Reference A/176/17/PL

I write to object to planning application for 2 houses on the Ham Manor Estate.

Street Elevation (1:200)

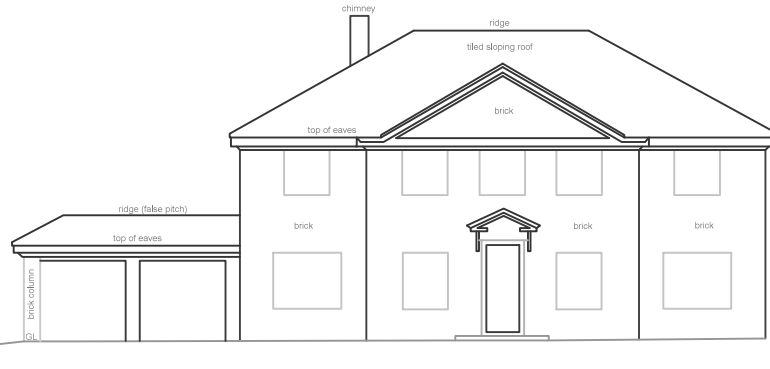
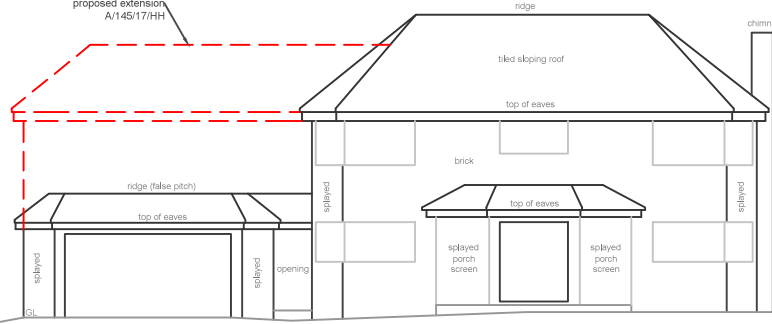
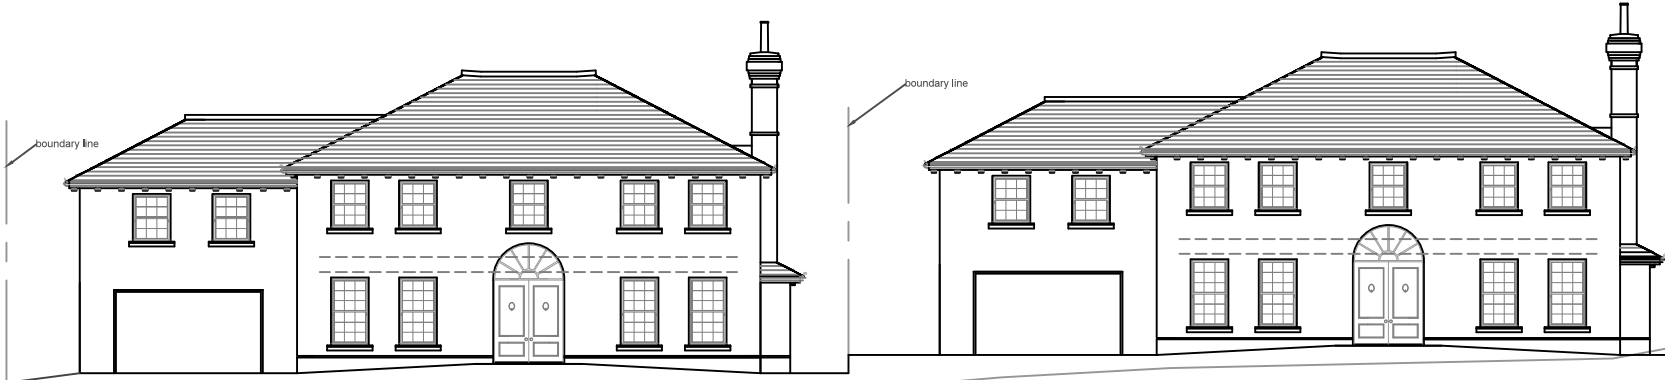
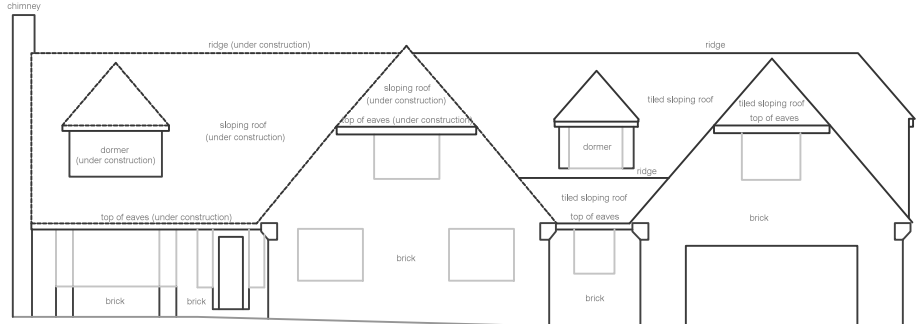
The size of these houses are huge and are taking up almost the complete plot width, they are out of keeping with similar houses in line with them, there will be a total lack of freedom of space and they will dwarf the bungalows opposite on a very narrow roadway.
